**Section 96A of the Town & Country Planning Act 1990 (as amended)
Town and Country Planning (Development Management Procedure) (England) Order 2015 (as amended) - Article 10**

Non-material amendment following the grant of reference K/26/18/HH for increase in length of extension by 0.5m, reposition of PVCu door on ground floor side elevation, orientation of bathroom en-suite changed at 90 degrees, 1 No. window rear rear elevation & 1 No. window side elevation with obscure glass and 1 No. window in bedroom extension on side elevation.

87 Golden Avenue East Preston BN16 1QT

DRAWING TITLE: PROPOSED EXTENSION
TITLE: 87 GOLDEN AVENUE
EAST PRESTON
SCALE: 1:100 U.O.S.
DATE: FEBRUARY 2018 REV 2 FEB 201
DRAW NO: SW SHEET 1 OF 5
NOTE: THIS DRAWING IS TO BE
READ IN CONJUNCTION WITH
APPENDIX A.

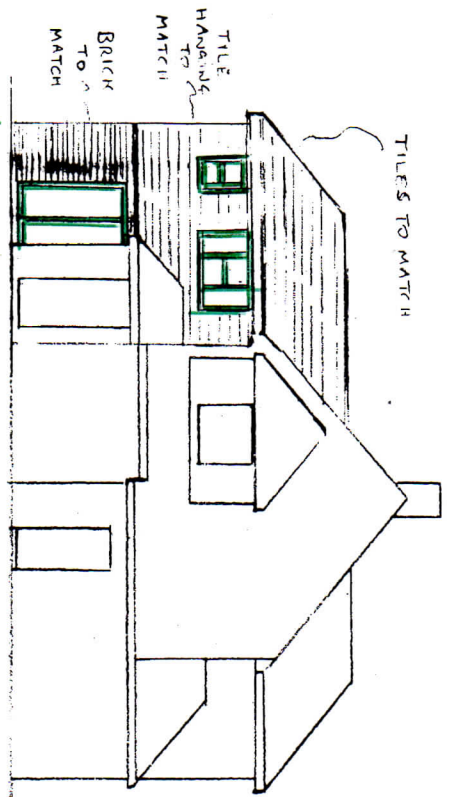
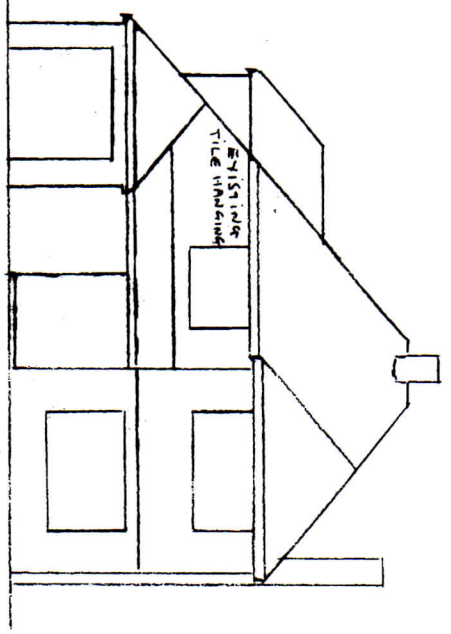
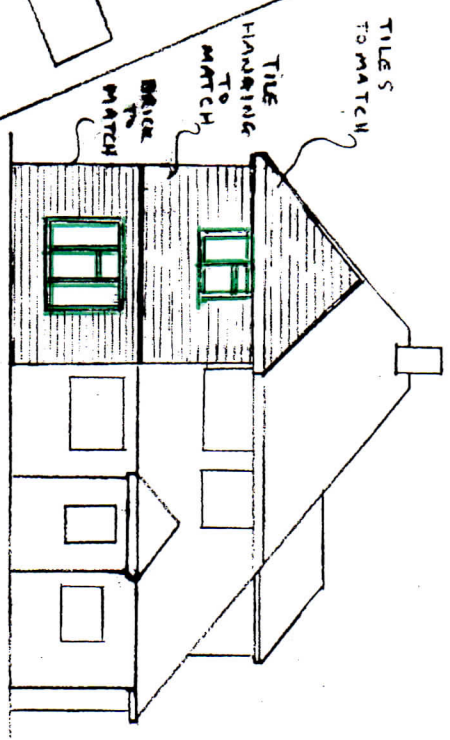
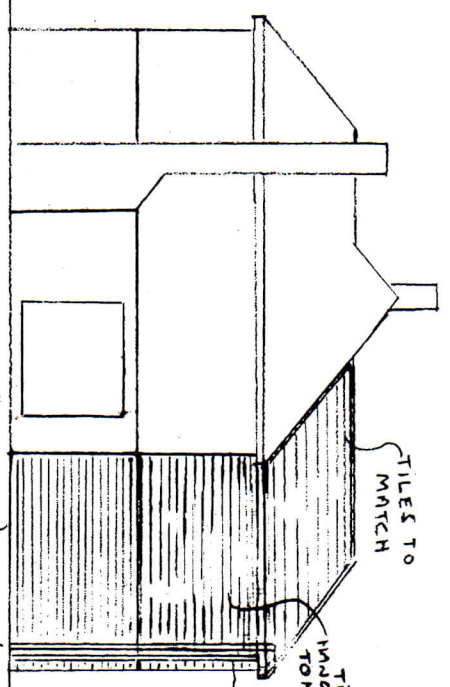
I refer to your recent application for a Non Material Minor Amendment. I note that you seek to lengthen the extension by 0.5m, and perform various alterations to the fenestration.

Please note that plan reference "Proposed Elevations - JW Sheet 1 of 5 - February 2018 - Rev. 2 - Feb 2019 - CHANGES TO PLANS ARE HIGHLIGHTES INDICATED IN GREEN INK" replaces "Proposed Extension - JW Sheet 1 of 5 - Rev. 1 - Aug 2018".
